DRB Application No.: 05DRB-00913 (SBP)
Project Name: ATRISCO BUSINESS PARK
Agent: John Klee

**CITY OF ALBUQUERQUE
PLANNING DEPARTMENT
June 8, 2005
DRB Comments**

RE: Albuquerque Vault Building Addition/spbp

SITE PLAN

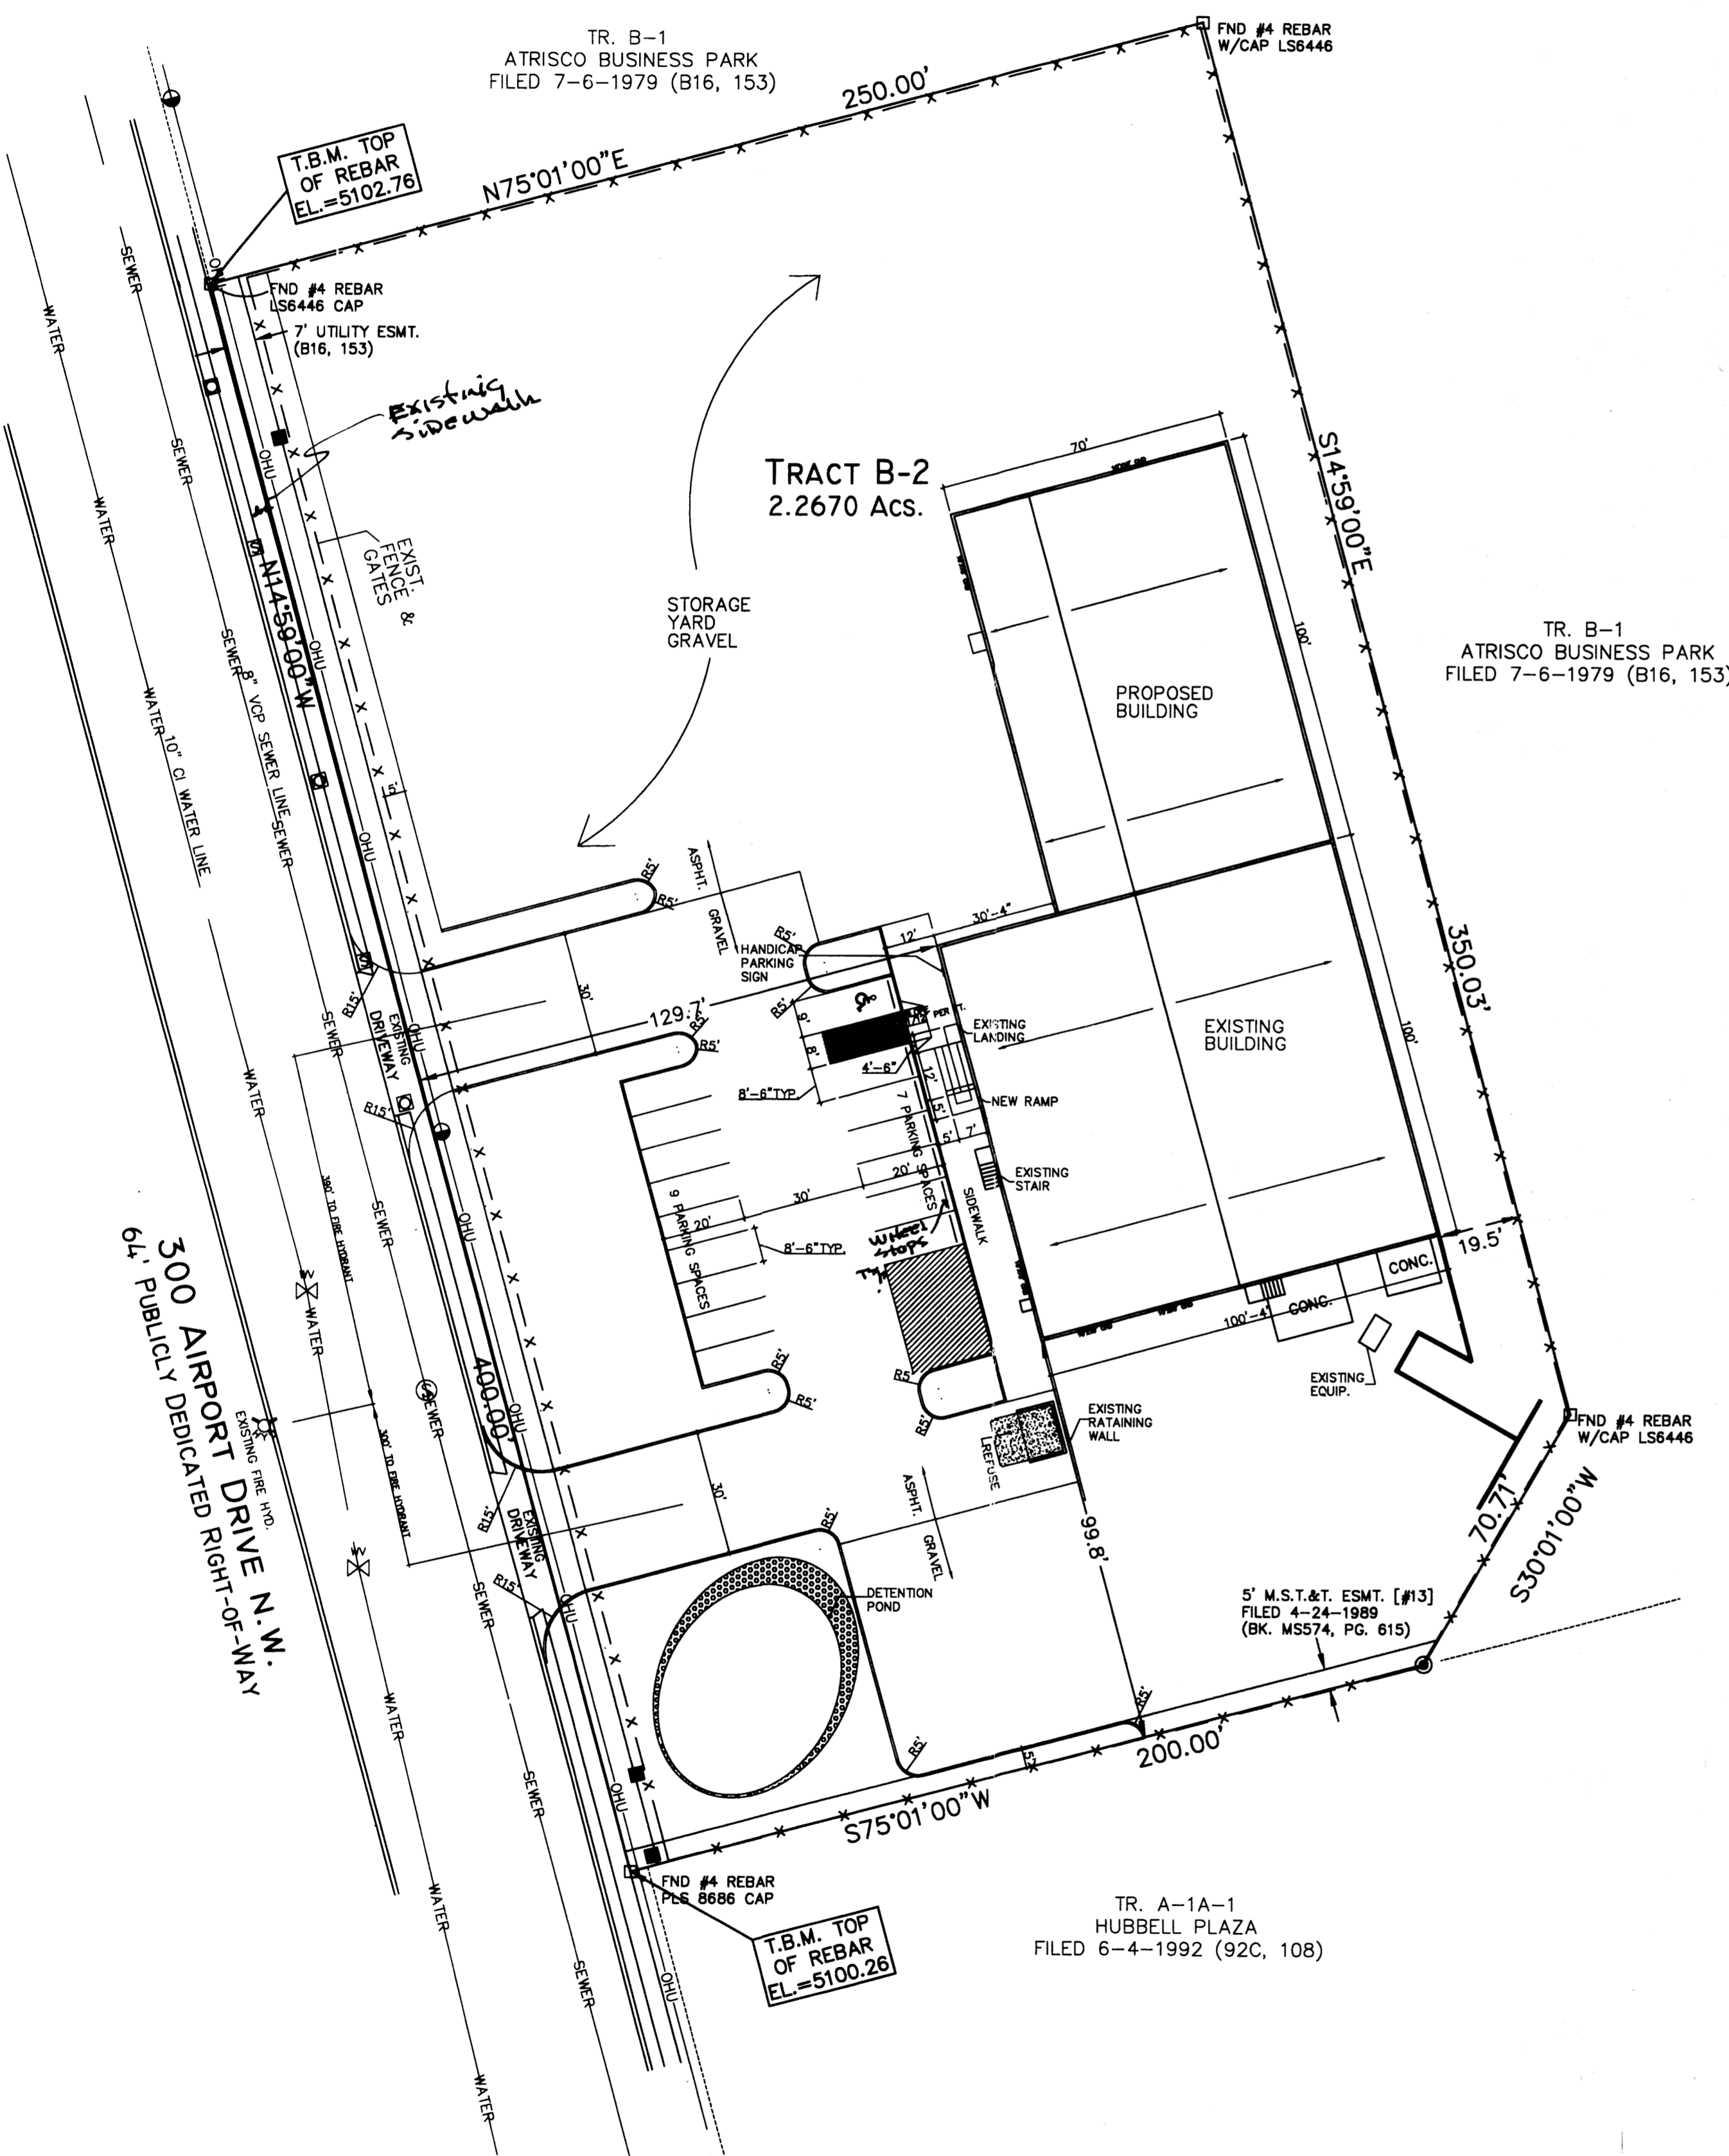
Are there any existing or proposed walls or fences?

Is there a loading facility planned as part of the addition? If so, please indicate on the site plan.

JOB TITLE:	ALB-VAULT		
REVISION:	FILE NAME	JOB NO.	DATE
			05-15-05
SHEET TITLE:	LANDSCAPE PLAN FOR BLDG. PERMIT		
	DRAWN BY	RI

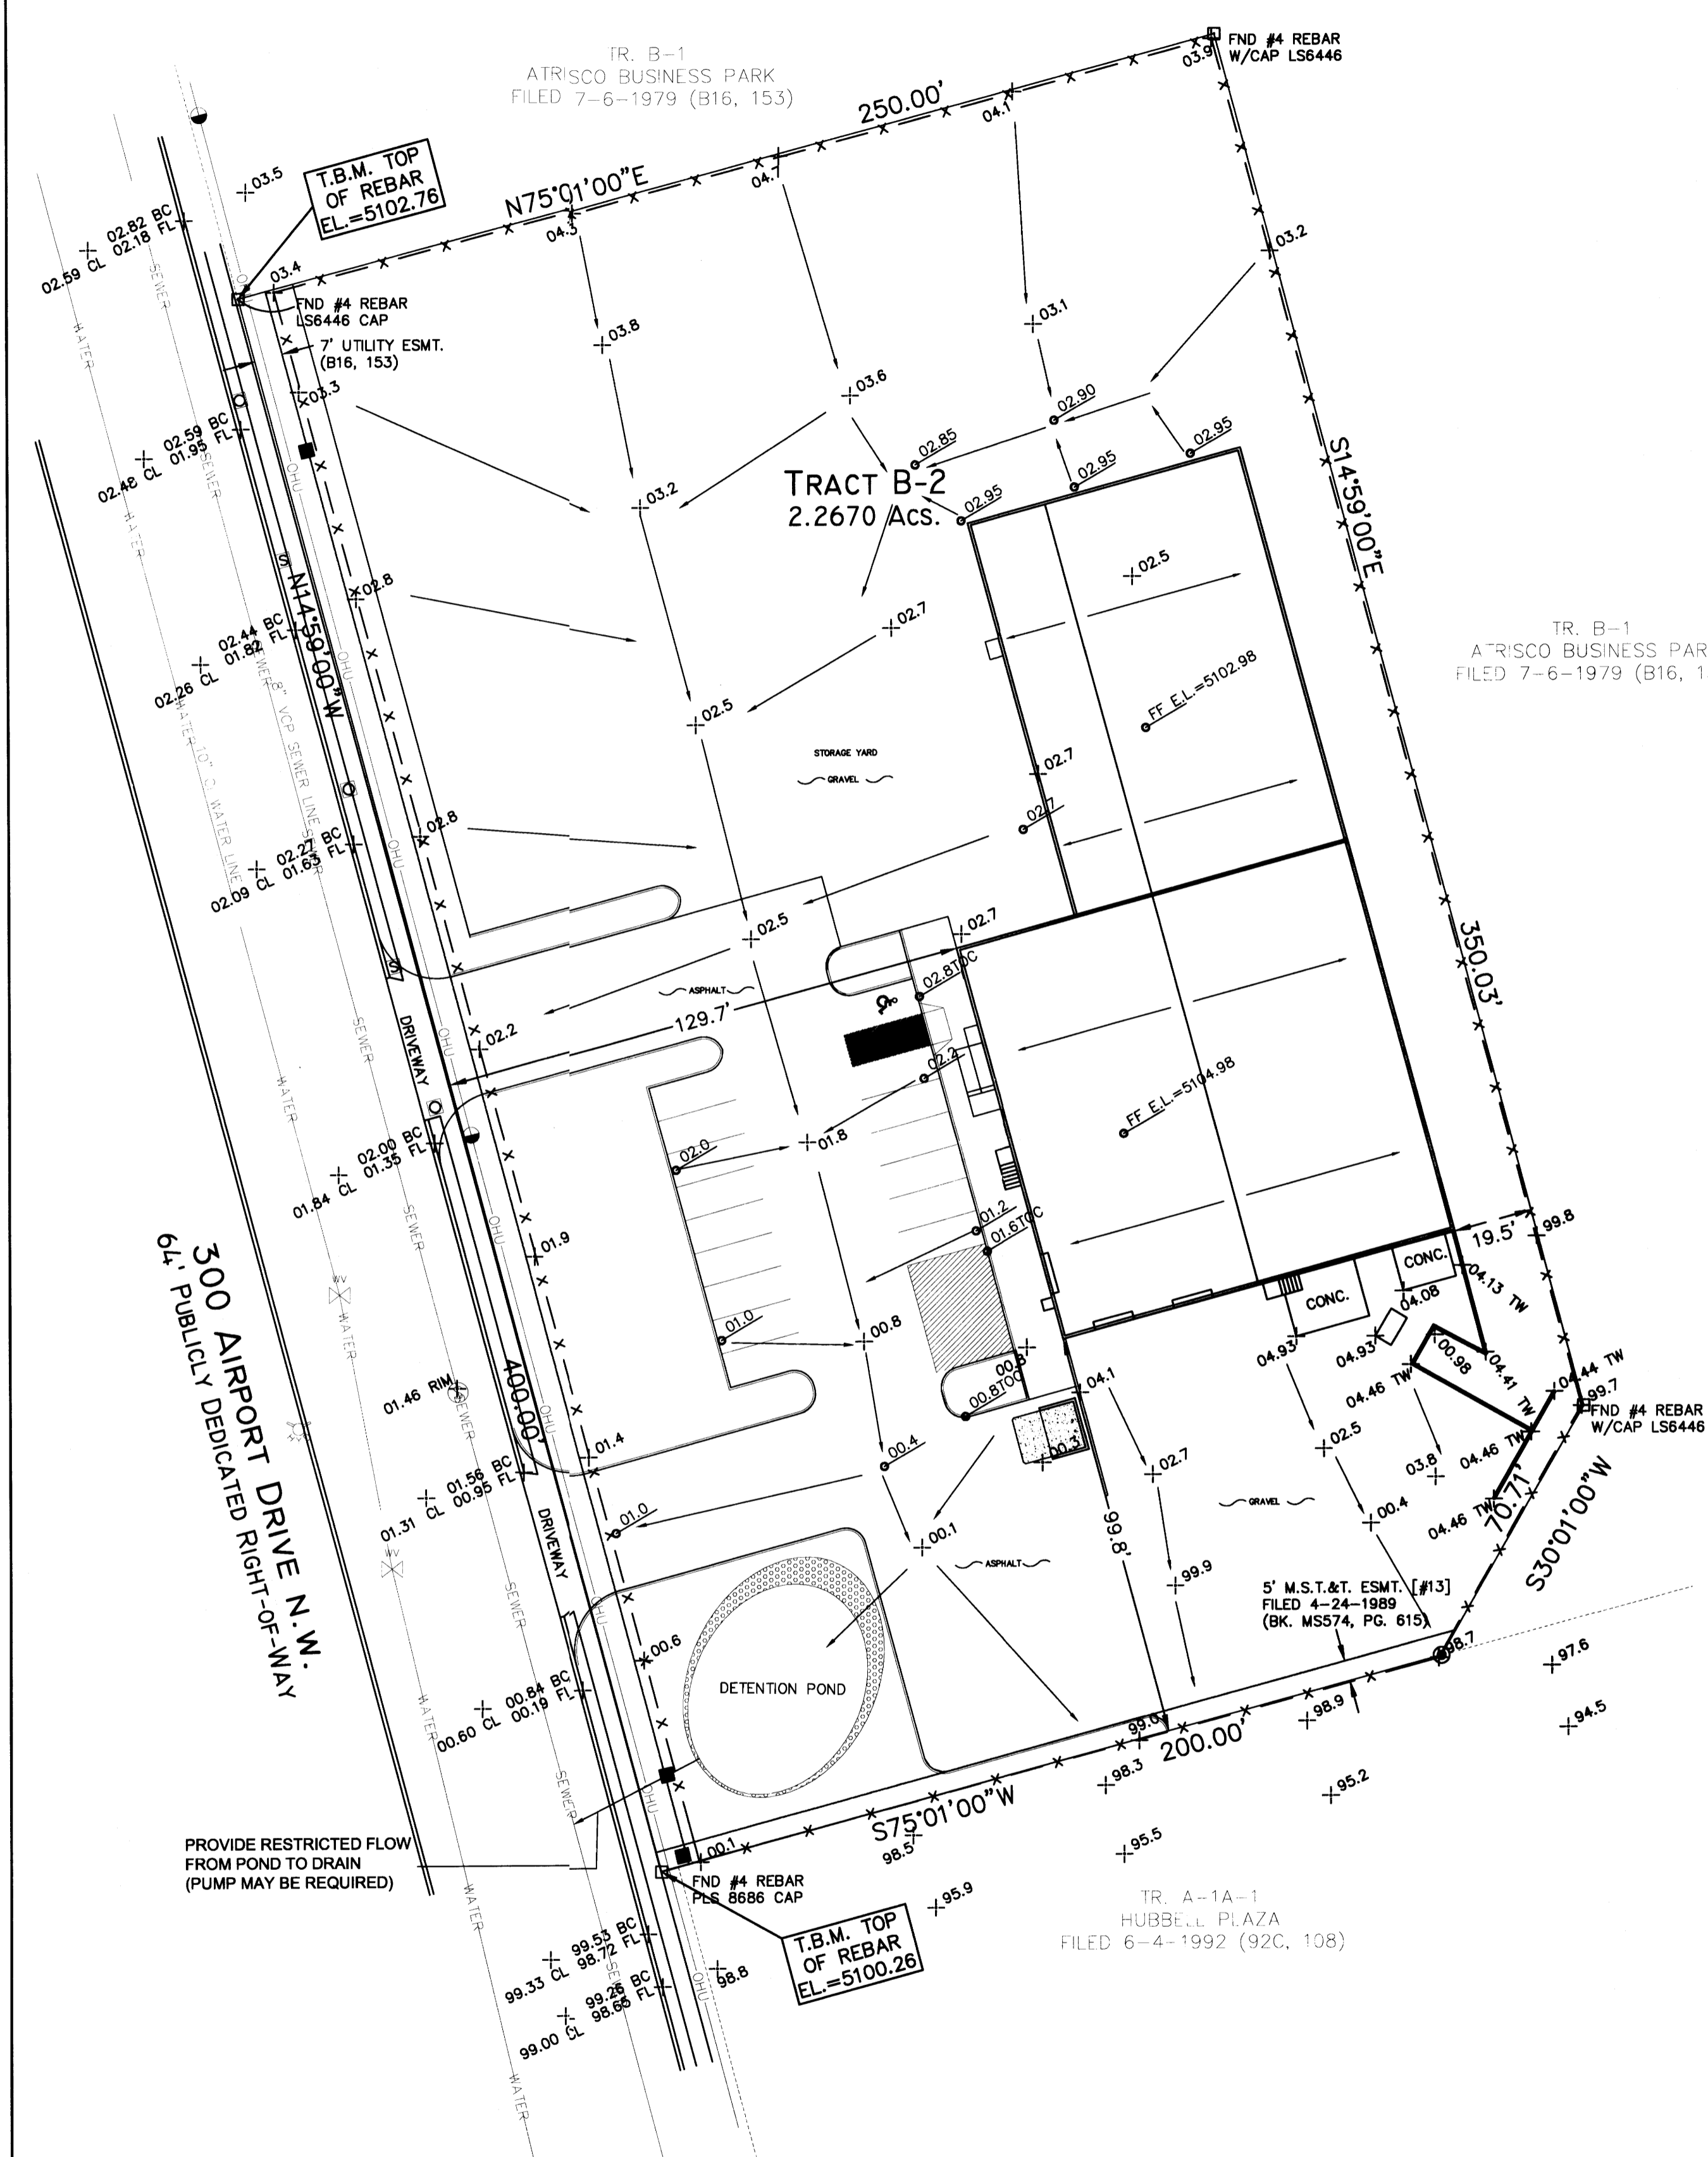
Please consider replacing the buffalo junipers with another shrub.

The first note on the Landscape Plan should include "& irrigation" after the word "landscape".
